From: Michael [REDACTED]
Sent: 20 May 2021 19:26
To: Energy Infrastructure Planning <beiseip@beis.gov.uk>
Subject: Norfolk Vanguard project EN010079 Norfolk Boreas Project EN010087

I write in response to email of 29th April, inviting comments regarding the Norfolk Vanguard and Norfolk Boreas projects, following the High Court's decision to quash the Norfolk Vanguard Offshore Wind Farm Order 2020.

Drawing file: EN010079 / EN010079-001897-Figure 29.09 Indicative Onshore Project Substation Mitigation Planting.pdf

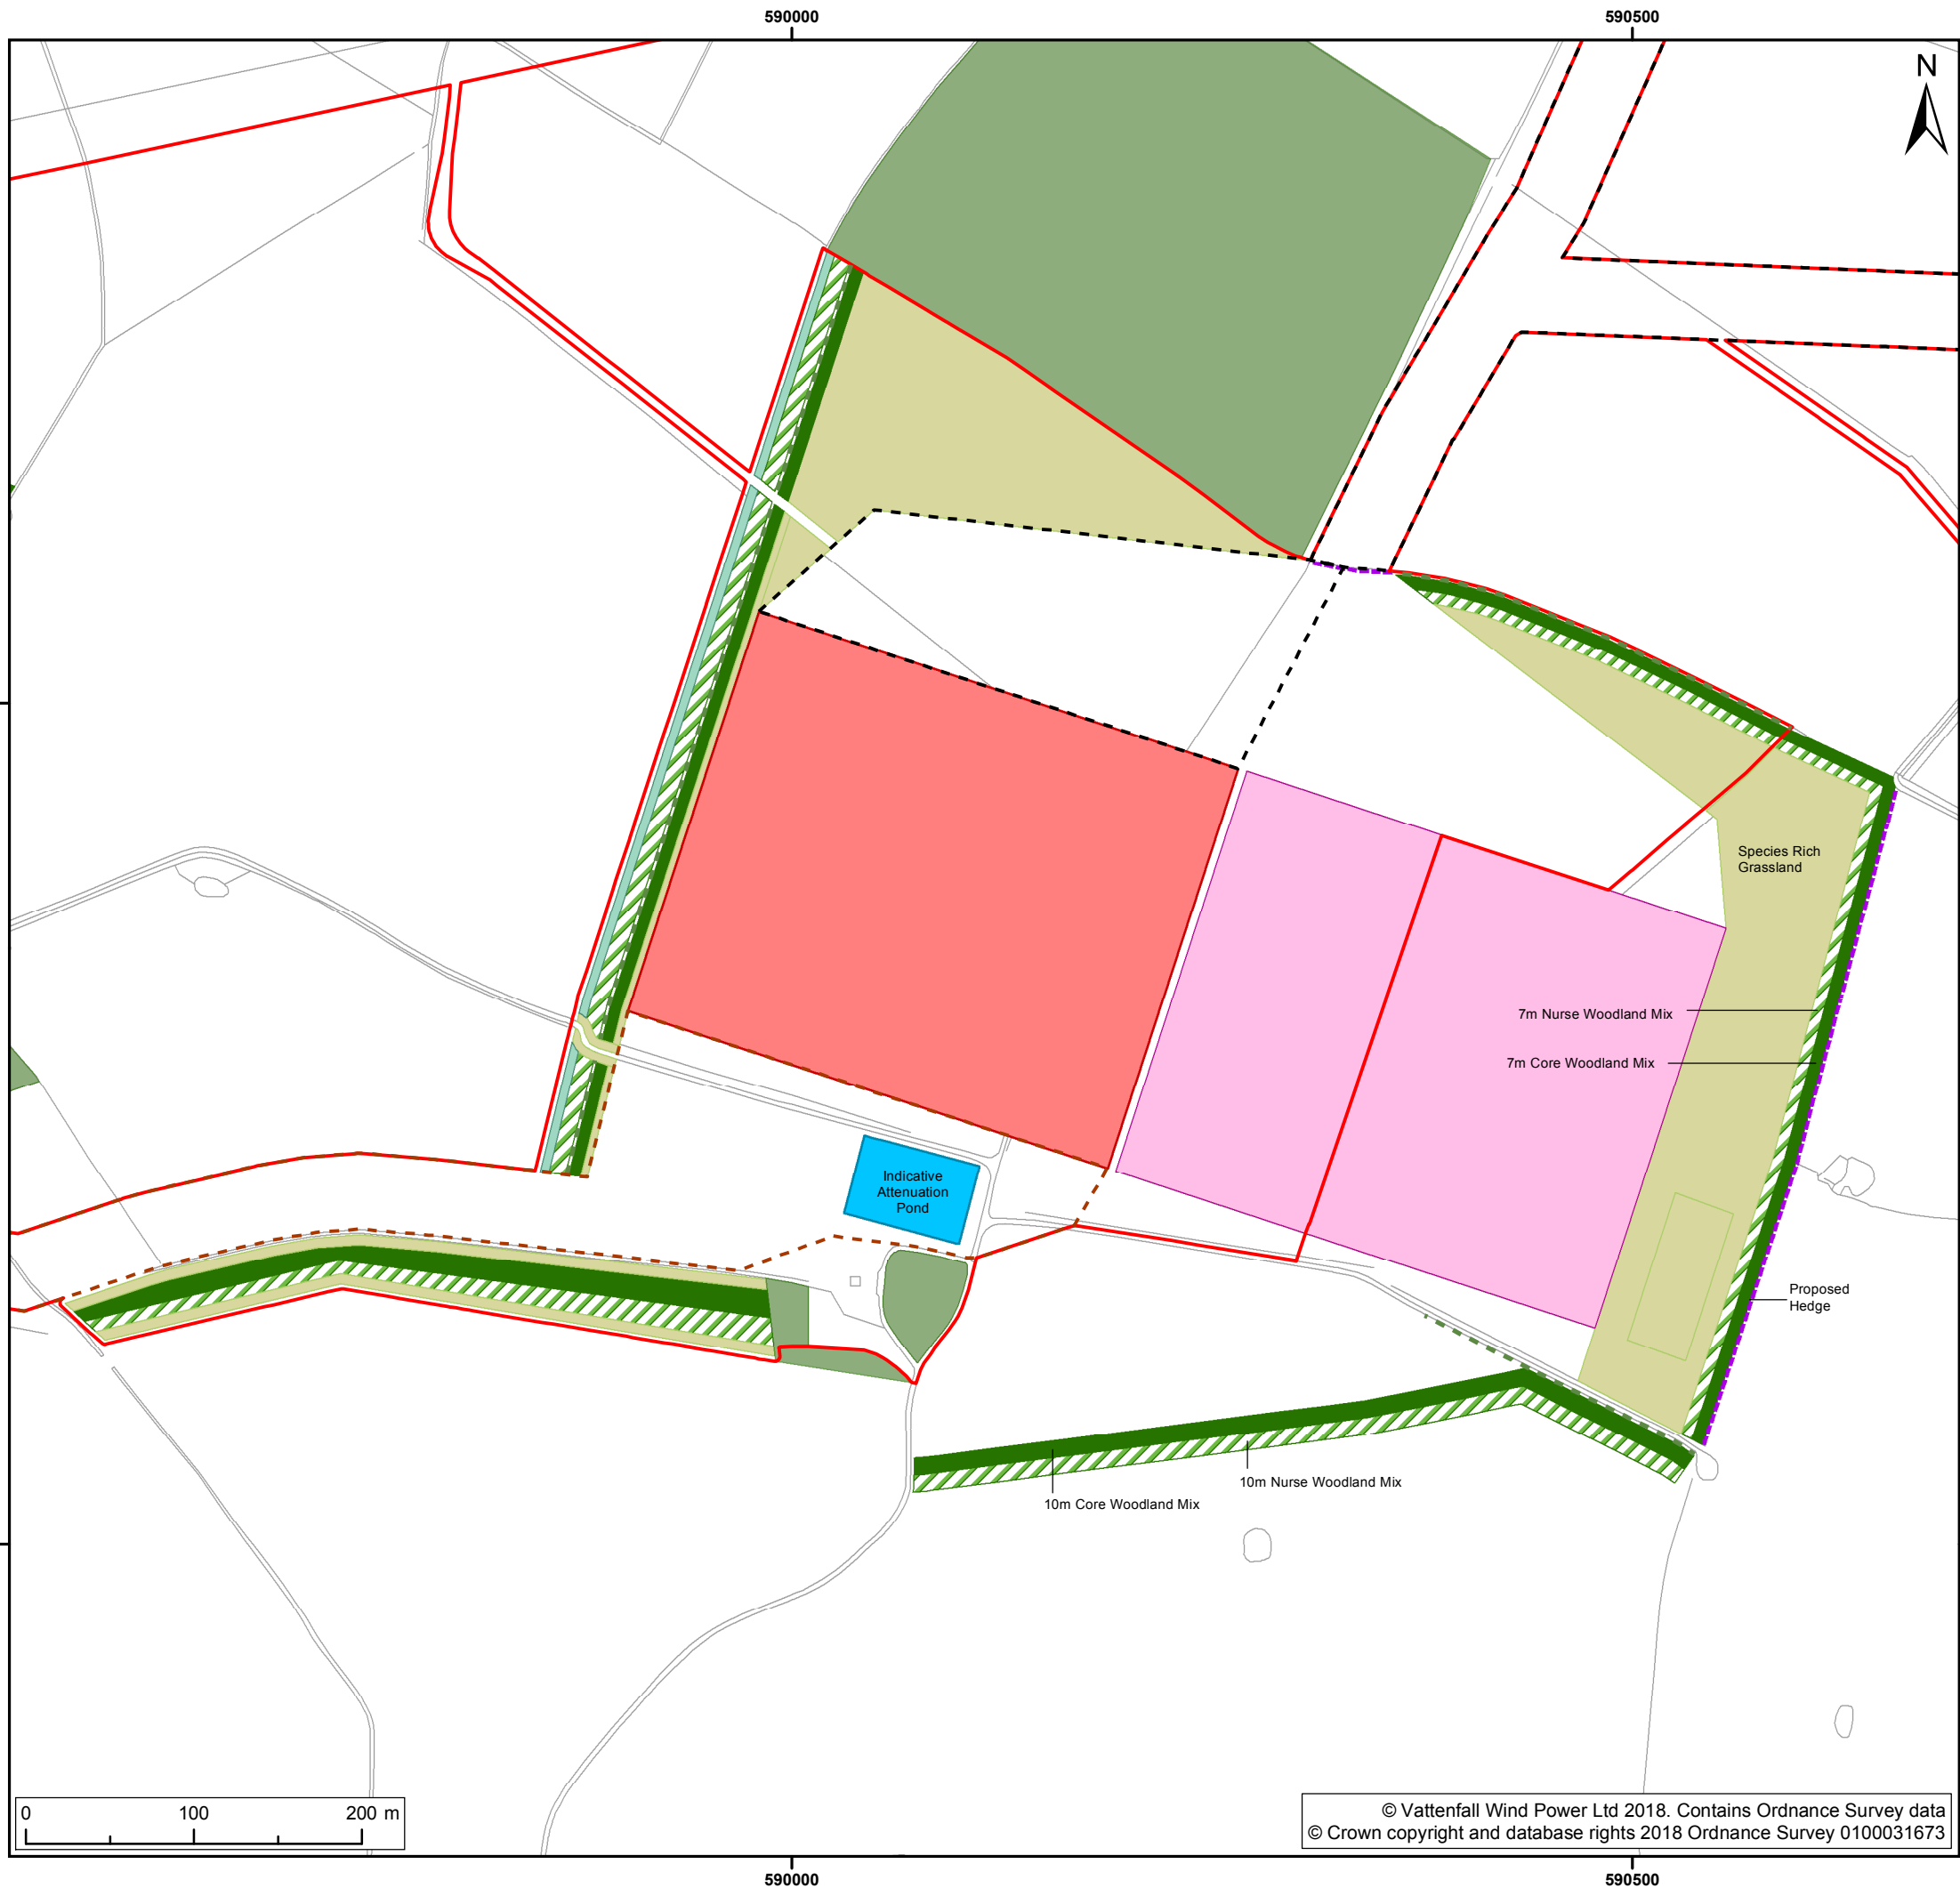
I would therefore like the planning to start again as one joint application between Vanguard and Boreas. The cumulative effects need to be scrutinised as a sole undertaking. It is important that size, visual mitigation and noise levels are redetermined cumulatively, since the singular Vattenfall project did not give acceptable importance to, or reporting of these factors. Vattenfall has suggested visual mitigation via tree planting, but how this could be achieved against the gigantic construction has not been made clear, nor any time scale suggested in order to achieve said mitigation.
